**re: Grading and Site Servicing Plans Review**  
**Proposed Apartment Building – Block 10**  
609 Longfields Drive – Ottawa, Ontario

**date:** January 17, 2025

**file:** PG2119-MEMO.21 Revision 1

Client/Project  
**CAMPANALE HOMES**  
200 - 1187 Bank Street, Ottawa, ON  
**609 LONGFIELDS DRIVE**  
**BLOCK 10**  
Ottawa, ON

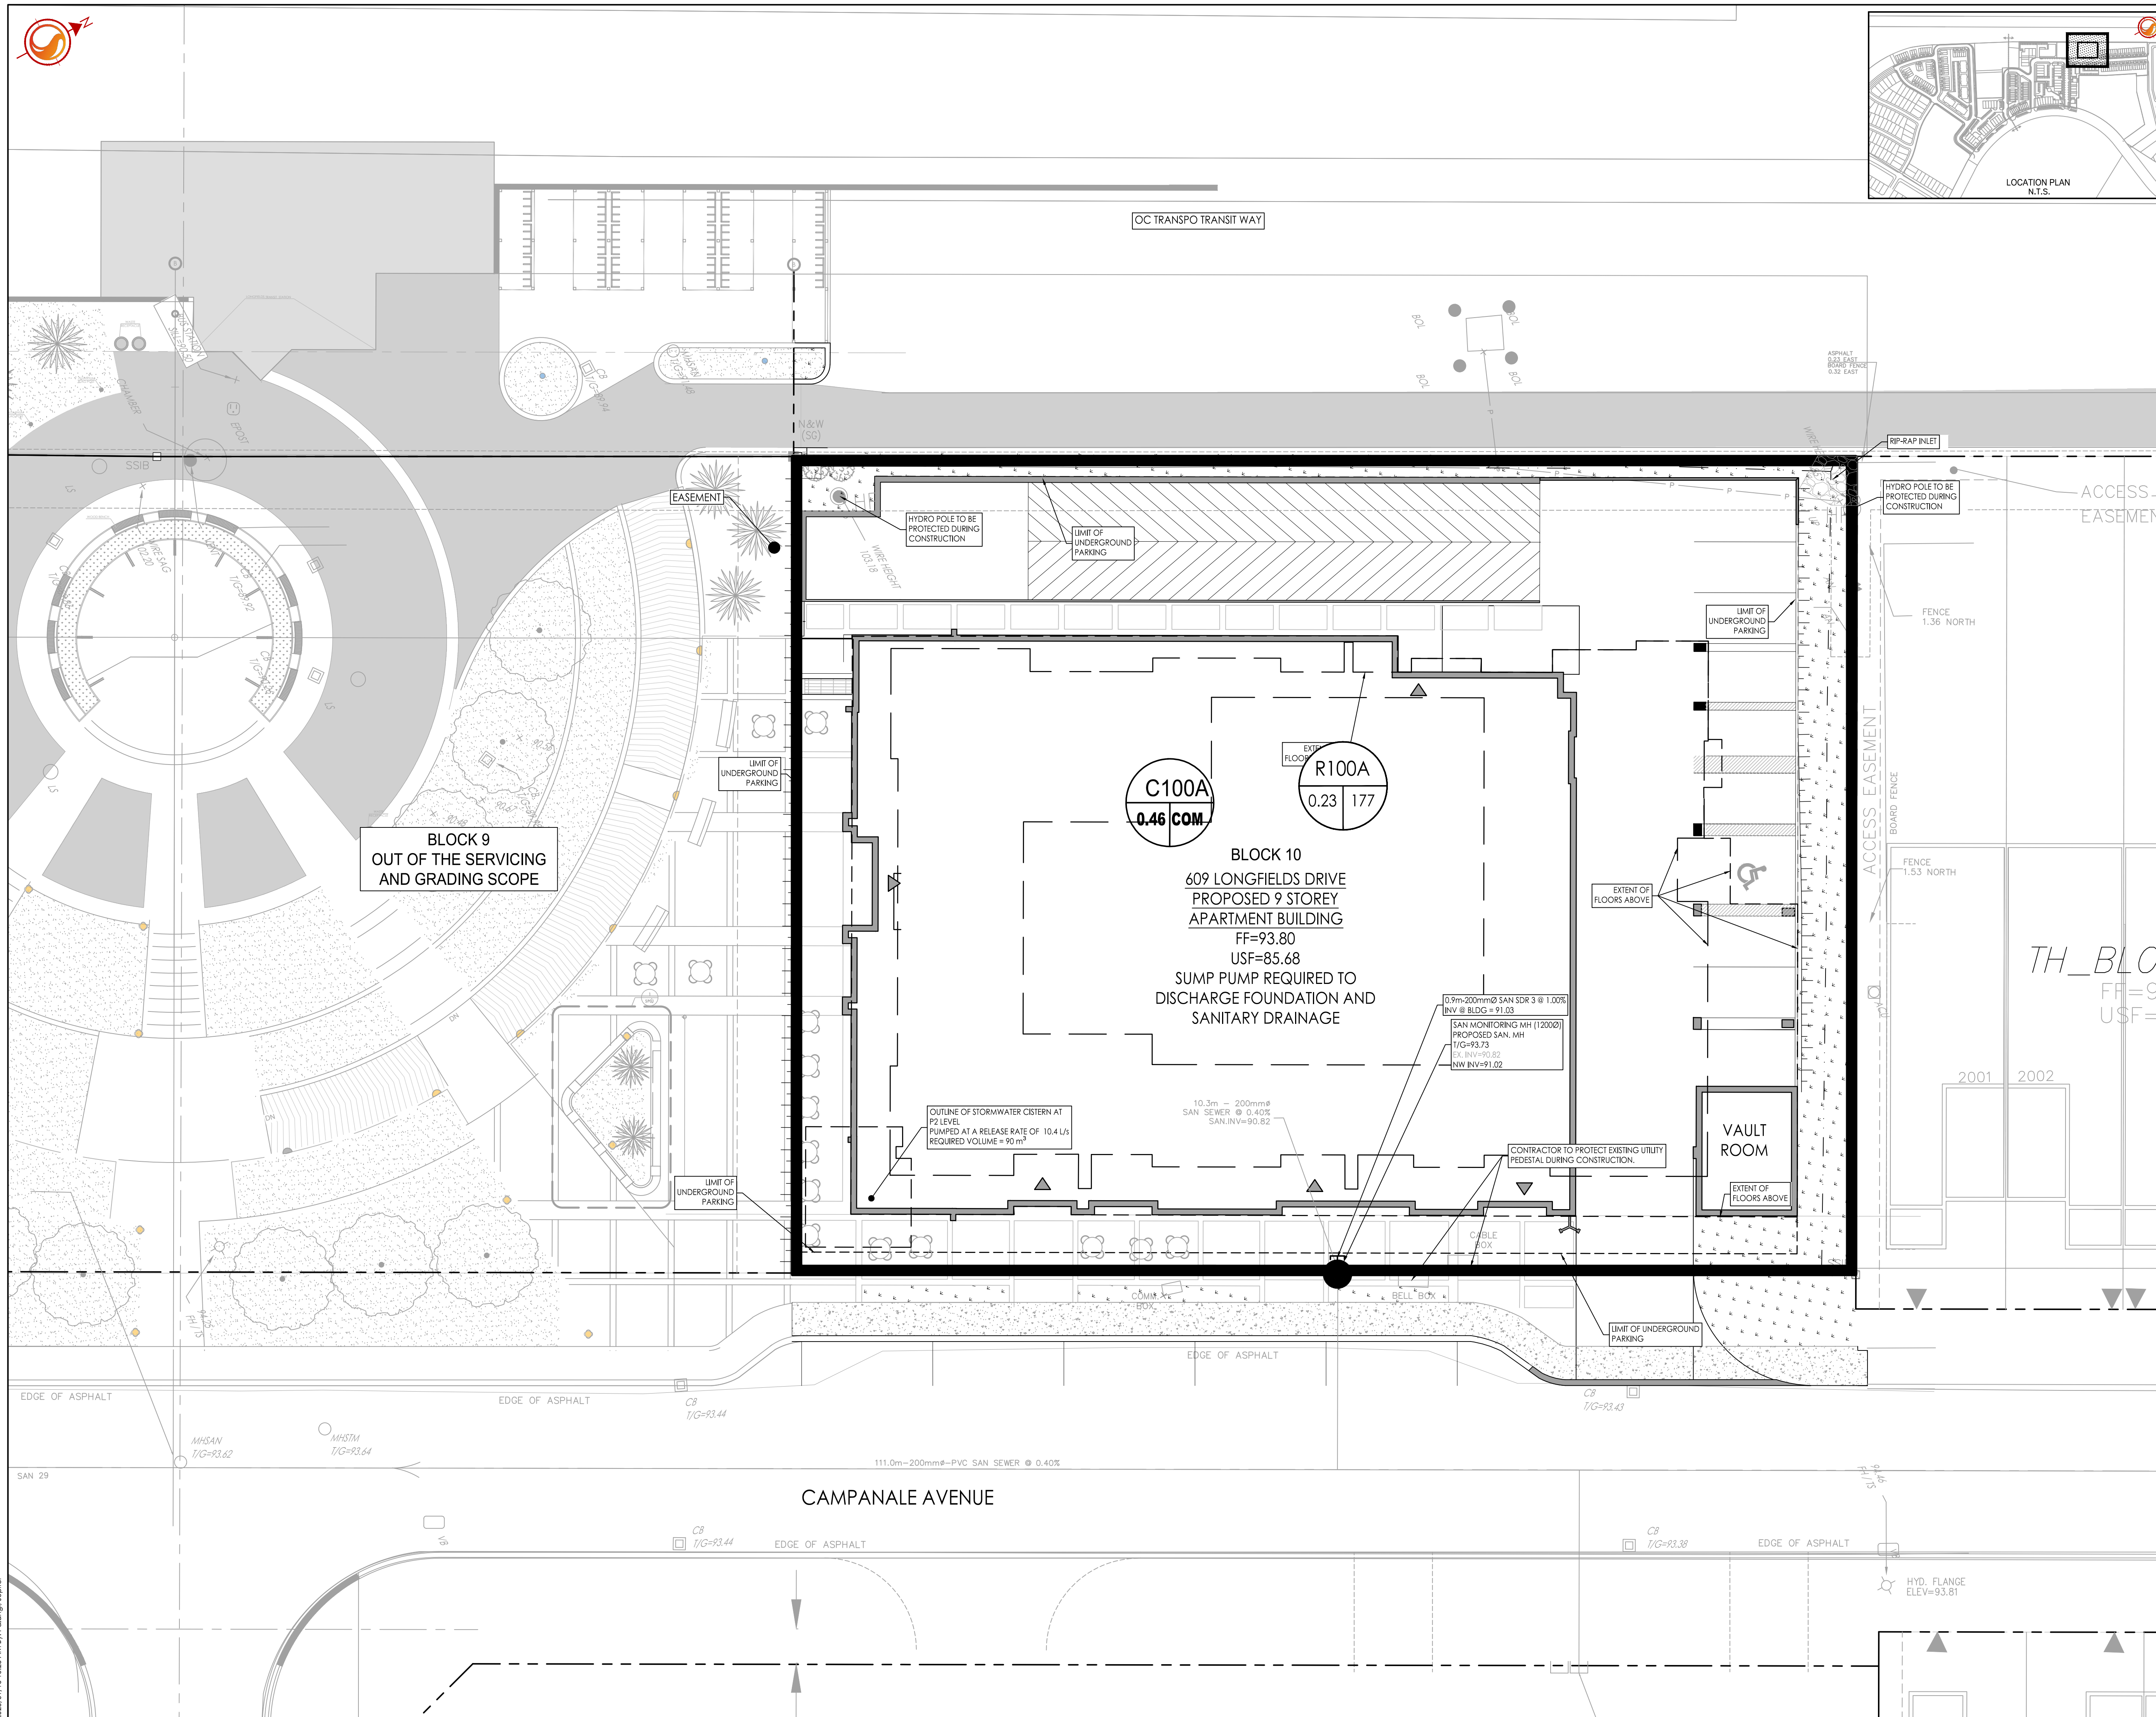
- Grading Plan – 609 Longfields Drive – Block 10 - Project No. 160401885 - Sheet No. 4 of 7 – Drawing No. GP-1 - Revision 2 dated January 14, 2025.

Based on our review of the above noted grading plan, the proposed grade raises within the aforementioned site are within the recommended permissible grade raise of 2.0 m. No exceedances were noted for any area within the subject site. Therefore, the proposed grade raises are generally acceptable from a geotechnical perspective and will not require the use of lightweight fill at this time.

Based on our review and given that the footings will be founded at a depth of approximately 7 m below the finished grade to accommodate two underground levels, no frost protection will be required for the proposed apartment building at the subject site.

- ❑ Site Servicing Plan – 609 Longfields Drive – Block 10 - Project No. 160401885 - Sheet No. 3 of 7 – Drawing No. SSP-1 - Revision 2 dated January 14, 2025.

Based on our review of the above-noted site service plan, it should be noted that all services will be constructed outside the lateral zones of the proposed footings of the building and are considered to be acceptable from a geotechnical perspective. Additionally, sufficient frost protection (more than 2.1 m soil cover) has been provided for all of the proposed service pipes including watermain, storm, and sanitary sewer pipes throughout the subject site.
